**KIRKLEES METROPOLITAN COUNCIL  
INVESTMENT & REGENERATION SERVICE**

**DELEGATED DECISION TO DETERMINE PLANNING APPLICATIONS**

Reference No:	<b>2025/62/92534/W</b>
Site Address:	40, Oldfield, Oldfield Road, Honley, Holmfirth, HD9 6RL
Description:	Installation of 12 solar panels to detached garage roof (within a Conservation Area)
Recommending Officer:	Joanna Rednall

**DECISION – CONDITIONAL FULL PERMISSION**

North East Elevation

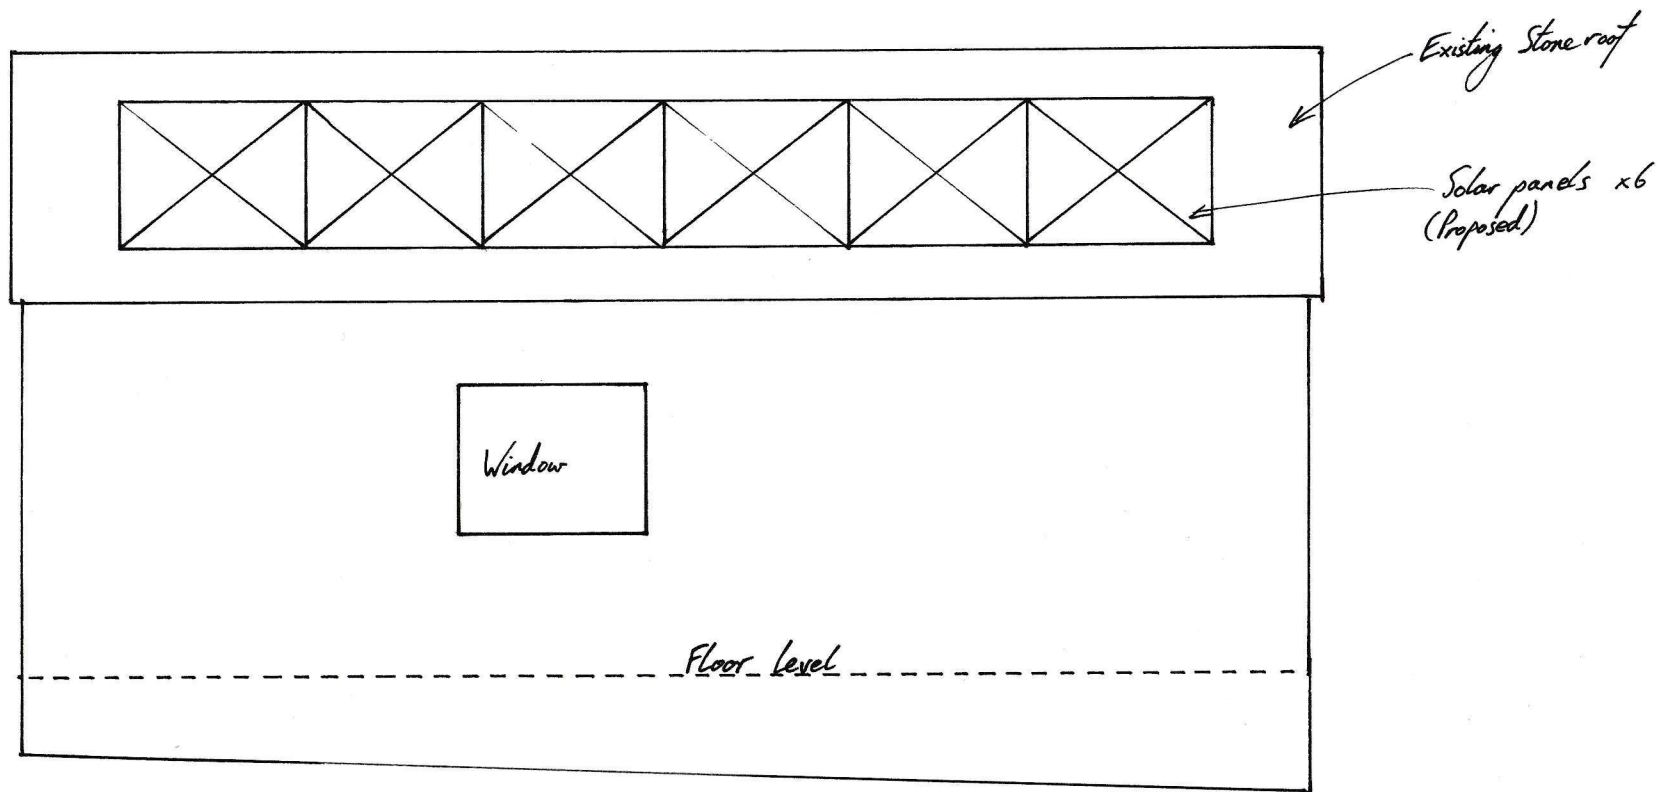
The proposed development involves installing a single row of six solar panels on each roof plane of the pitched garage roof (12 in total). Officers consider that, although the installation would introduce a modern intervention within the Oldfield Conservation Area, its visual impact would be limited to the roof slope of the existing outbuilding. The panels would be visible from public vantage points, particularly when approaching from Oldfield to the east, but their flush, integrated positioning within the roof plane and their matt black finish would help reduce their prominence at street level.

The panels would be set well clear of both the eaves and the ridge and would follow the existing roof pitch, ensuring the original roof form remains clearly legible around them. The submitted heritage statement sets out that while the farmhouse makes a strong positive contribution to the area's character through its stone construction, roof form, and intact traditional features, the detached garage contributes less to the site's overall heritage value. Therefore, the applicant contends restricting the solar installation to the garage roof therefore avoids any direct impact on the farmhouse's primary historic fabric and positive contribution towards the setting and character of Oldfield Conservation Area.

The panels would be integrated into the roof surface, lying flush with the tiles and avoiding any projection above the roofline. Given the site's location within a valley, the use of matt black, uniformly arranged panels with no visible silver lines and a non-reflective coating would further minimise visual intrusion.

3. The solar panels shall be constructed using black glass and black frames and retained as such thereafter.  
**Reason:** To conserve the significance of the Conservation Area in the interests of visual amenity in accordance with Policies LP24 and LP35 of the Kirklees Local Plan and policies within Chapters 12 and 16 of the National Planning Policy Framework.

4. Notwithstanding the submitted information the solar panels hereby approved shall have an anti-reflective coating applied prior to their installation which shall be retained thereafter.
